At a meeting of the Barnham and Eastergate Parish Council's Planning & Environment Committee held on 2nd March 2021 the Committee resolved to submit an objection response to the above application.

Application No: BN/10/21/HH

Site Address: 2 Park Cottages Goodacres Barnham PO22 0JE

Description of Works: Loft conversion consisting of hip-to-gable roof extension and rear box dormer with roof windows to front elevation.

Drawing
Proposed Elevations

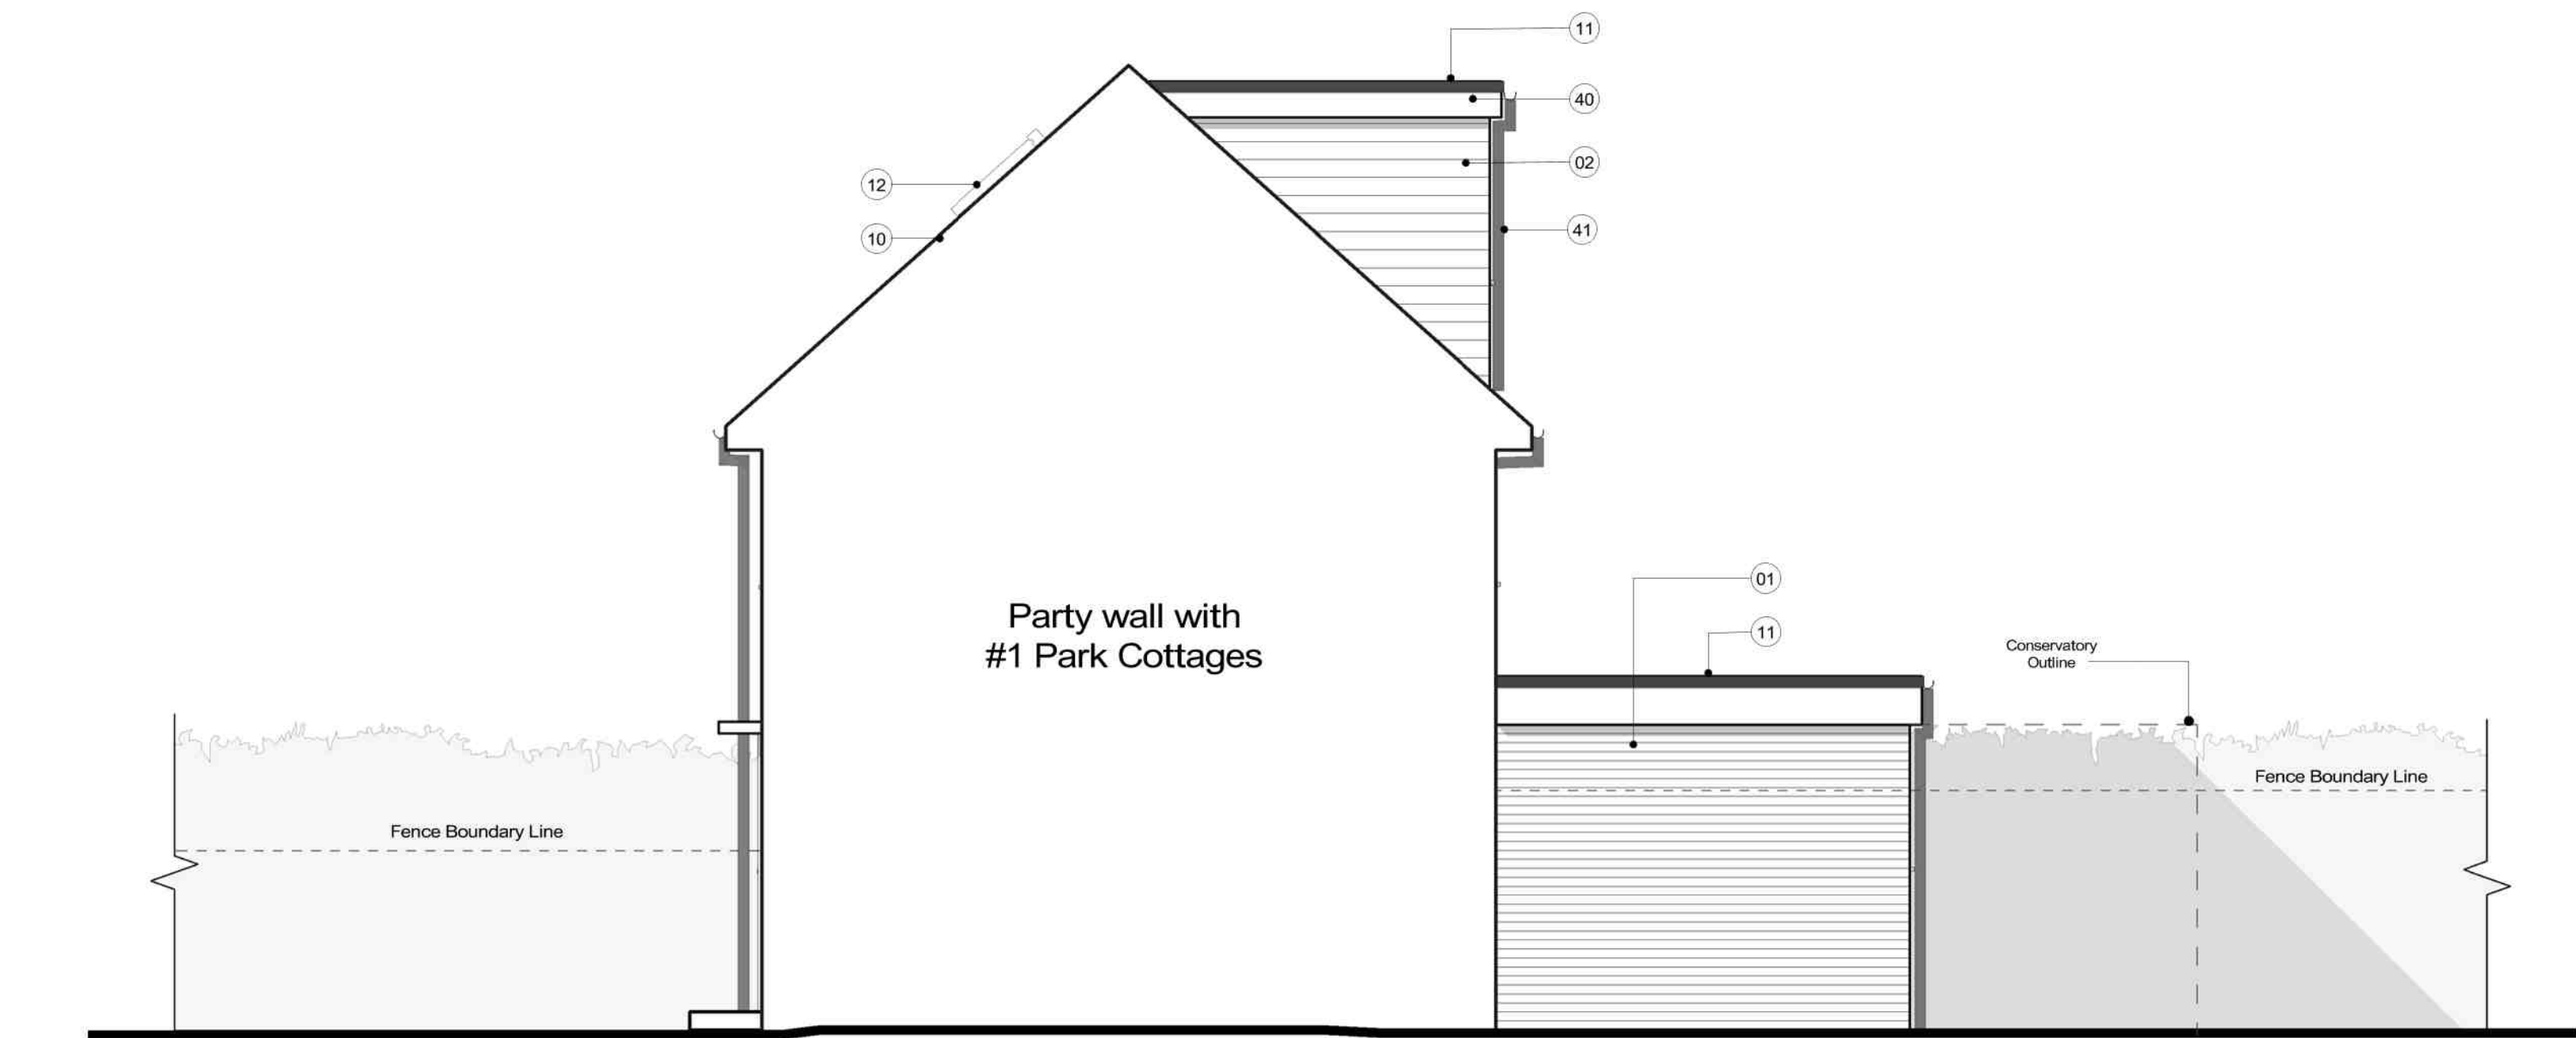
The Committee feel that the design in terms of it's size and visual impact on the surrounding area is oversize and needs reconsideration. Policy H4 of the Barnham and Eastergate Neighbourhood Plan makes reference to the design of new housing development and whilst it doesn't specific existing property changes the Committee would ask that the policy be taken into consideration when major extensions and changes to existing properties are being put forward within the Parish.

Similarly Policy ES6 refers to contribution to local character and again whilst specifically aimed at new development the Committee would ask that it be taken into consideration when major extensions and changes to existing properties are being put forward.
